Please ask for: Ms Iqraa Malik
Email: iqraa.malik@terraquest.co.uk
Telephone: 01212341390
Our Ref: M/121/21/HH
Your Ref:
Date: 25th August 2021

Application for Planning Permission for Works or Extension to a Dwelling

Development: Retention of two storey rear extension, conversion of garage to habitable use, 3 x side dormers and 1 x rear dormer with balcony
Location: Driftwood Manor Way Elmer Middleton-On-Sea PO22 6LA

Ground Floor

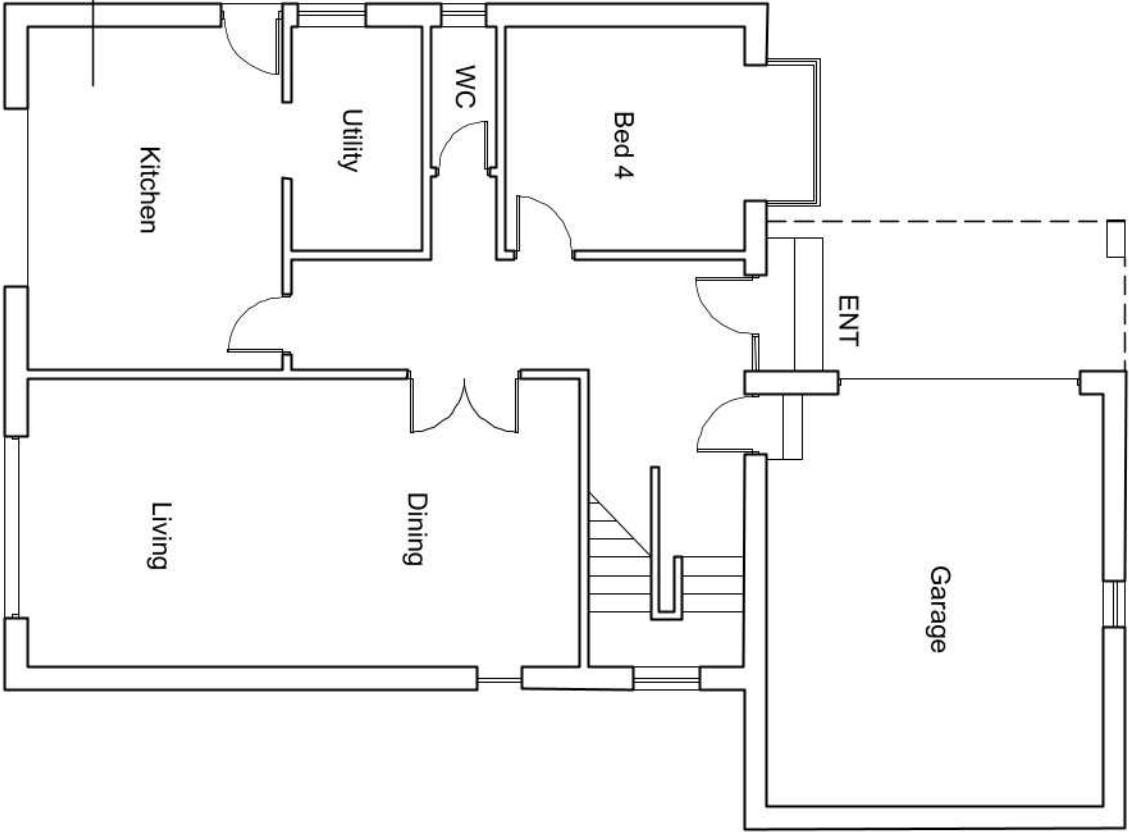
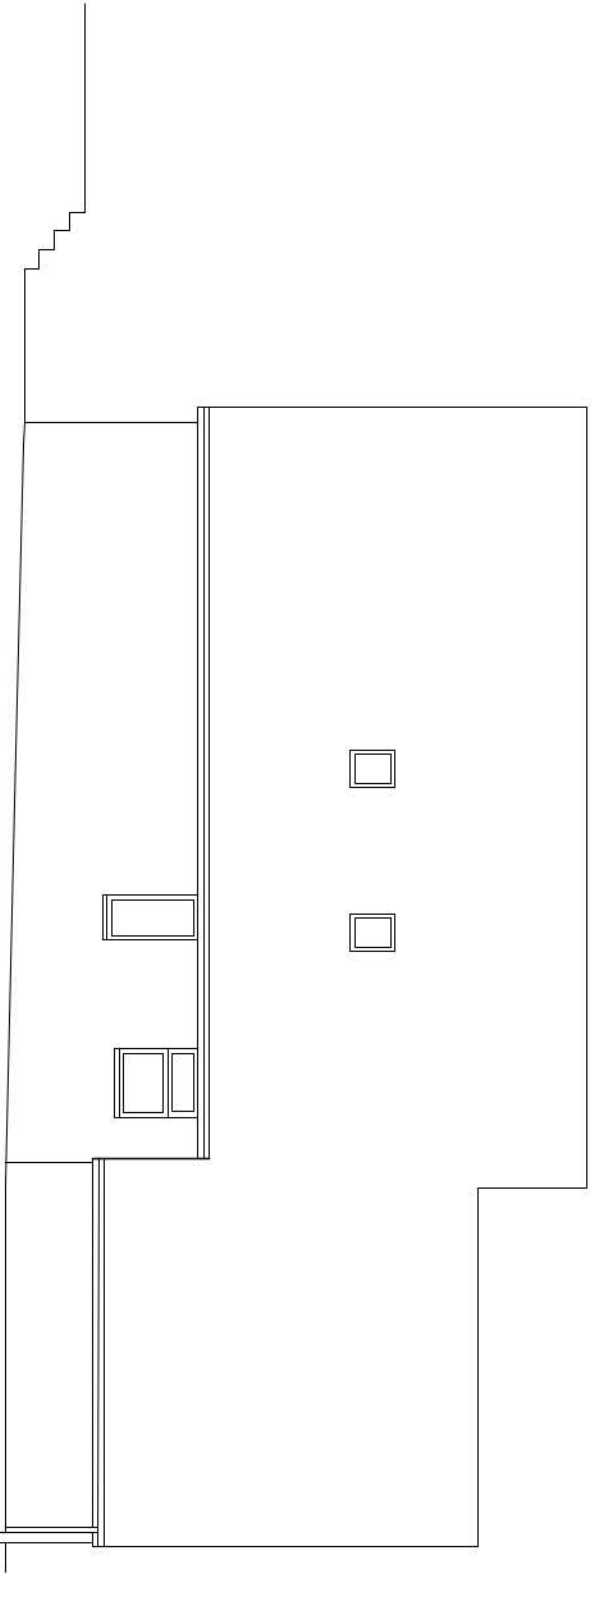
The garage and garden room window measures inconsistently between the existing/proposed ground floor plan and the existing/proposed north elevation. Please amend

First Floor

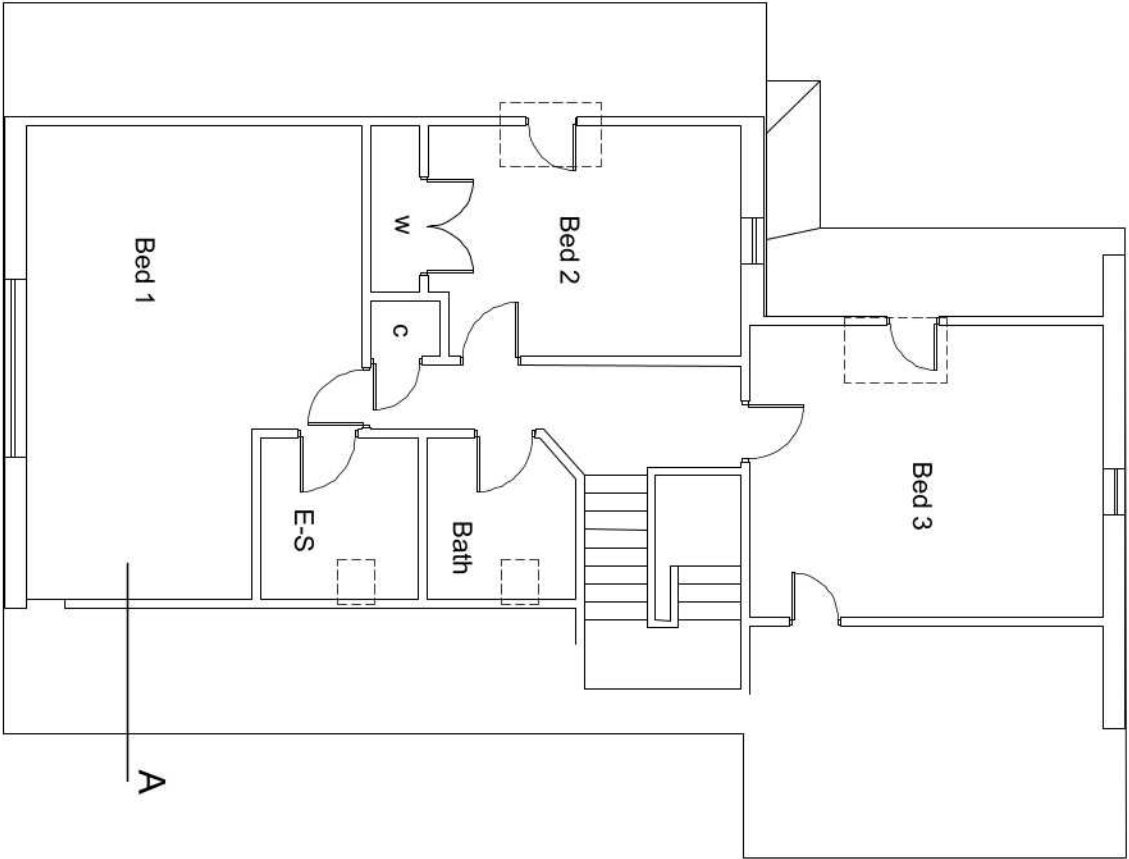
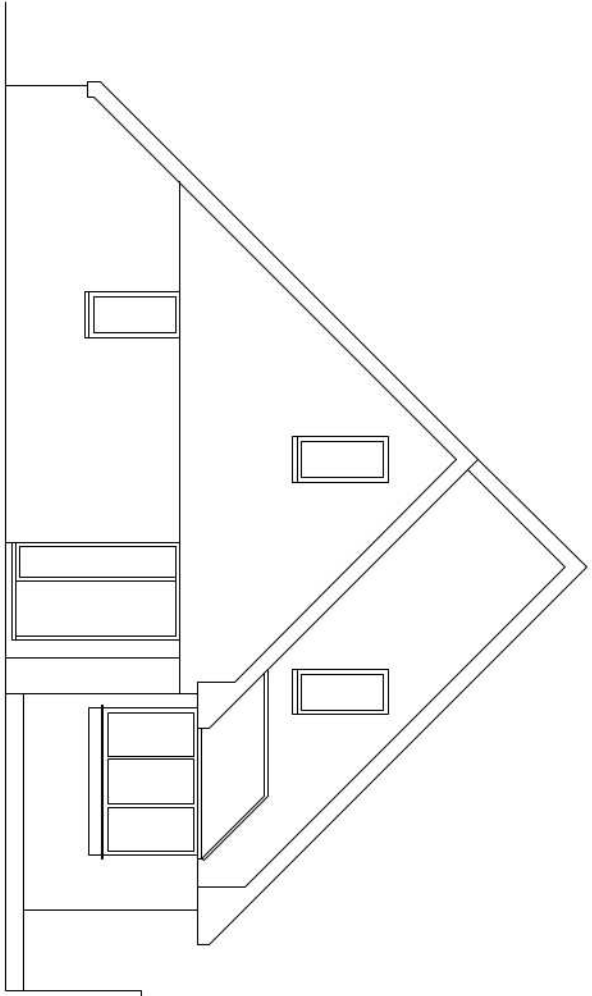
The windows are inconsistent between the existing first floor and existing west/east elevations. Along with this, they are also inconsistent between the proposed first floor plan and the proposed west elevation. Please review and amend.

Existing Plans & Elevations

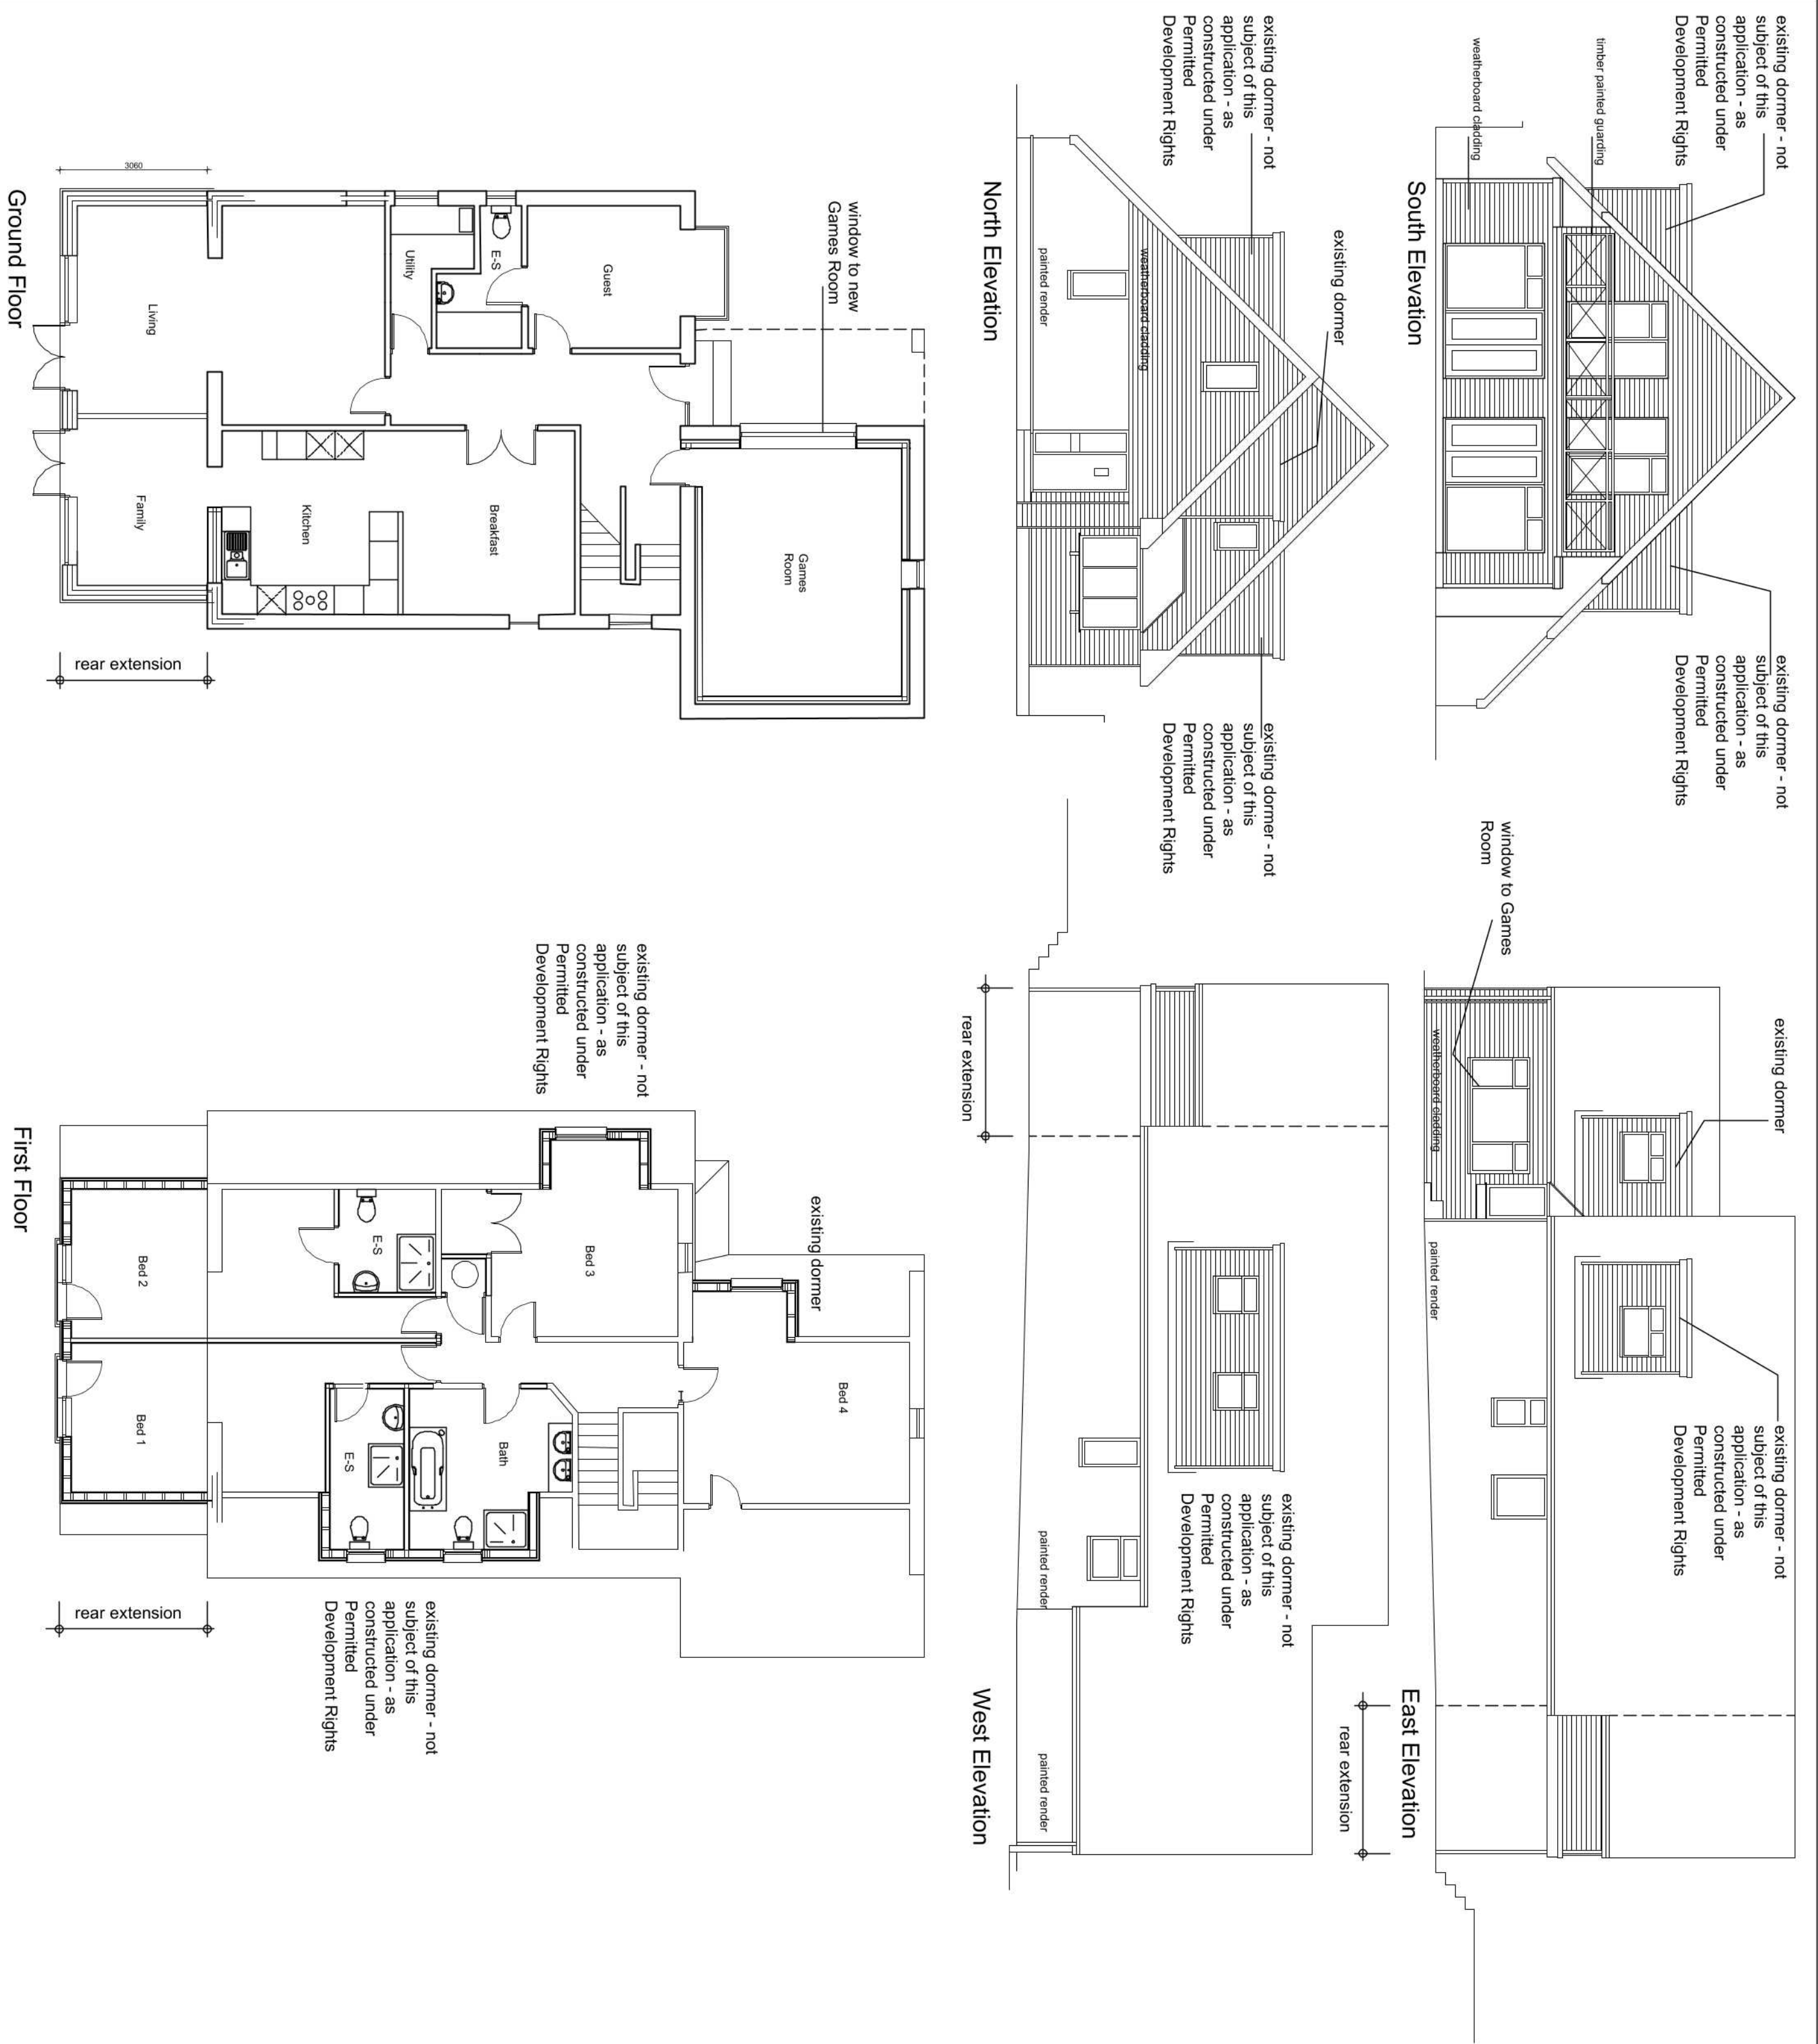
As the works have already been completed, please amend labels of the existing plans to 'pre-existing' and proposed plans to 'existing'.
